Our Ref: AL/5/18/RES
Your Ref:

19th January 2018

Application for Approval of Reserved Matters Following Outline Approval

Development Approval of reserved matters following outline consent AL/75/14/OUT for 2 No. dwellings.
Location Woodgate Farm Westergate Street Westergate

Ordnance Survey (c) Crown Copyright 2017. All rights reserved. Licence number 100022432
SITE LOCATION PLAN 1:1250

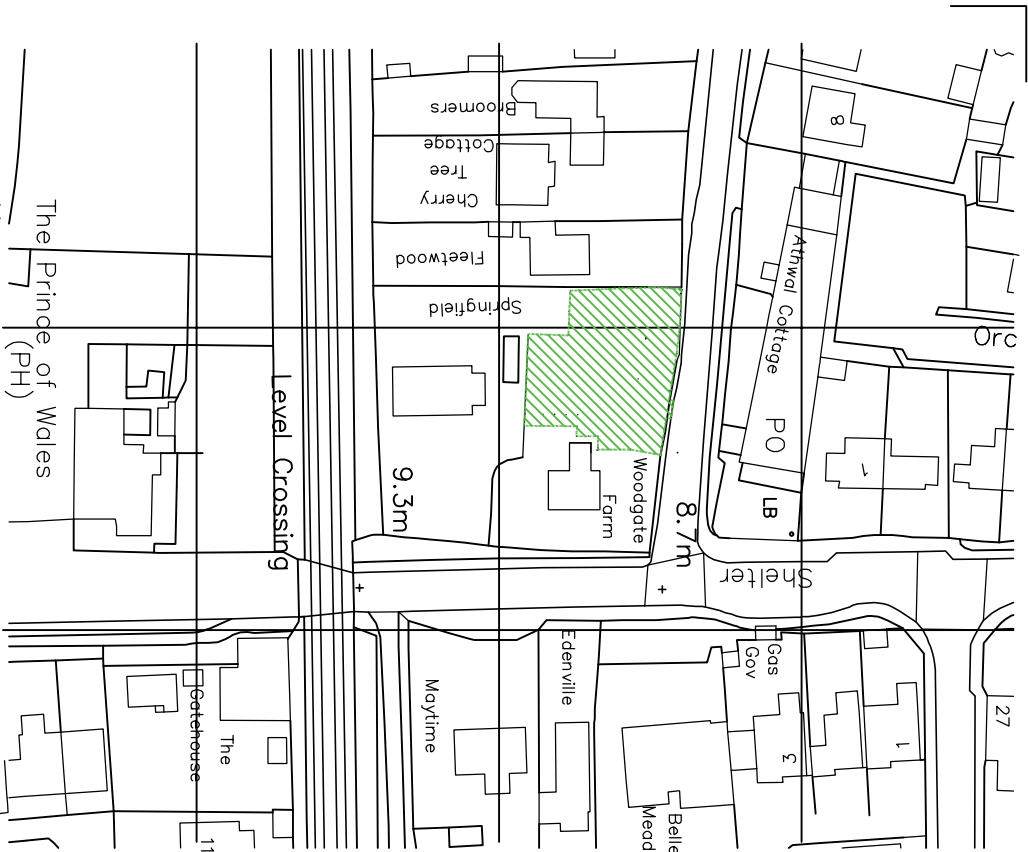
Location Plan Amend

Please submit 1 electronic or 3 paper copies of a location plan at a scale of 1:1250 or 1:2500 for rural areas. Further details of what must be included on the plan can be found in the National Validation Requirements. Please provide two named roads.

The red and blue edges differ from AL/75/14/OUT and this application. The red and blue edges on this application must match the red and blue edges on AL/75/14/OUT. Please amend accordingly.

SITE PLAN - PROPOSED WORKS 1:200

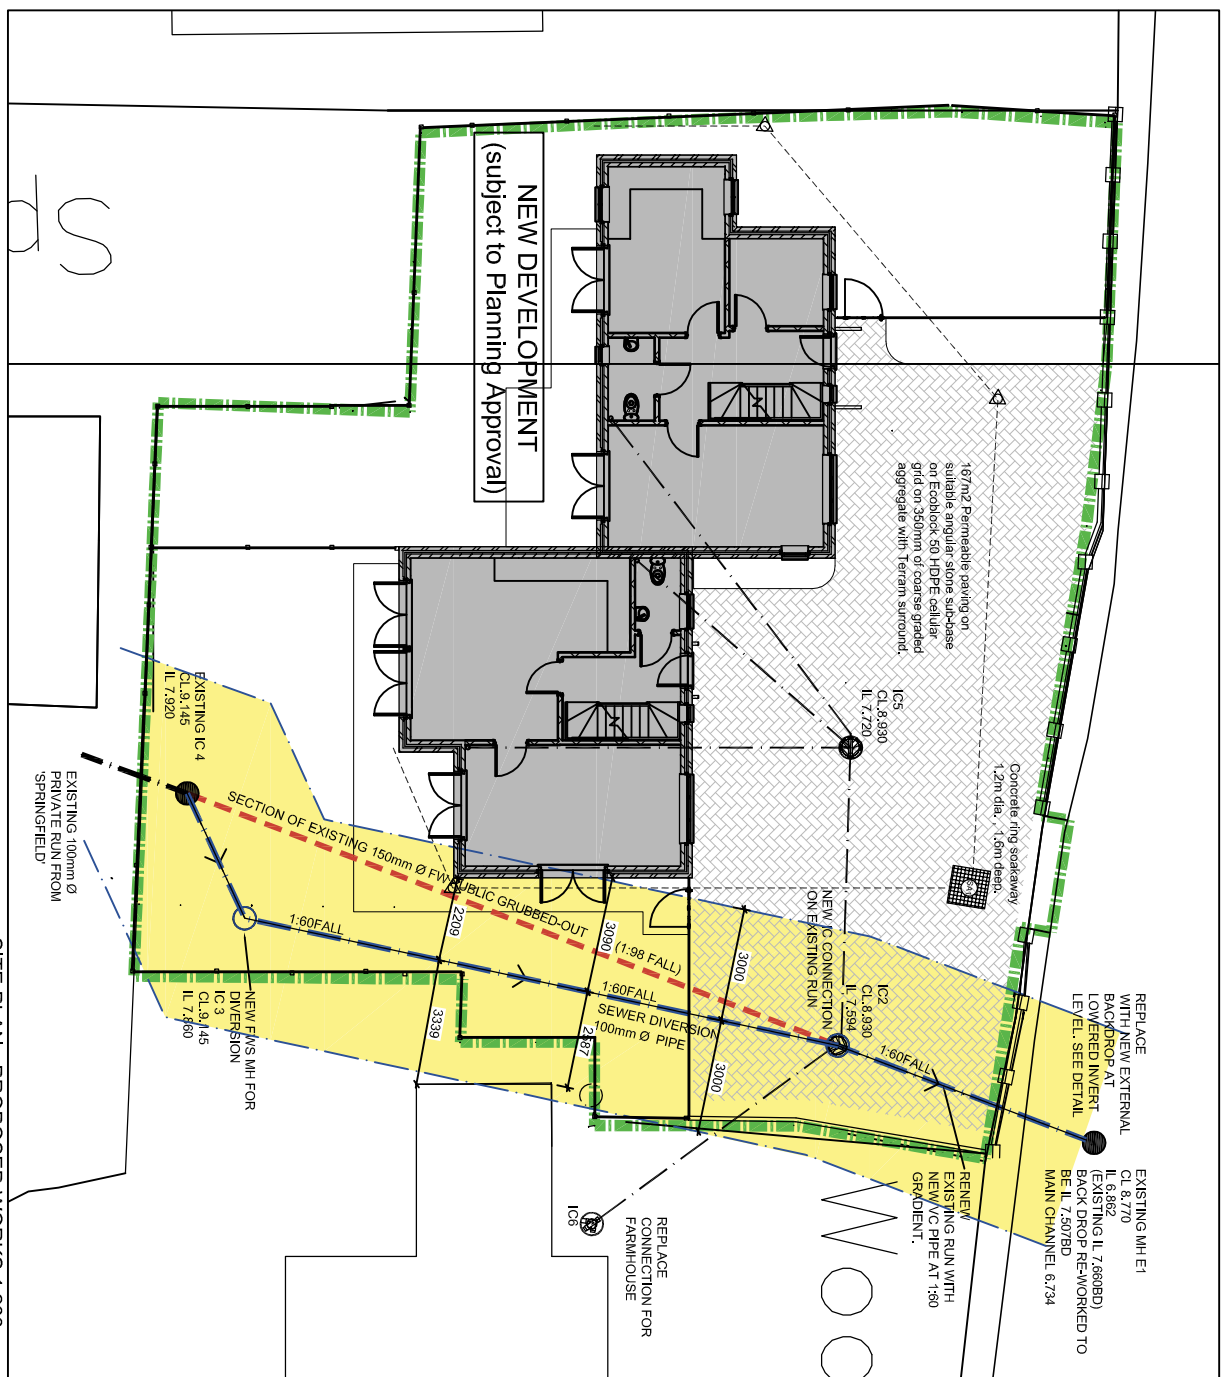
On the site plan, please provide measurements from the proposals to the site boundaries.
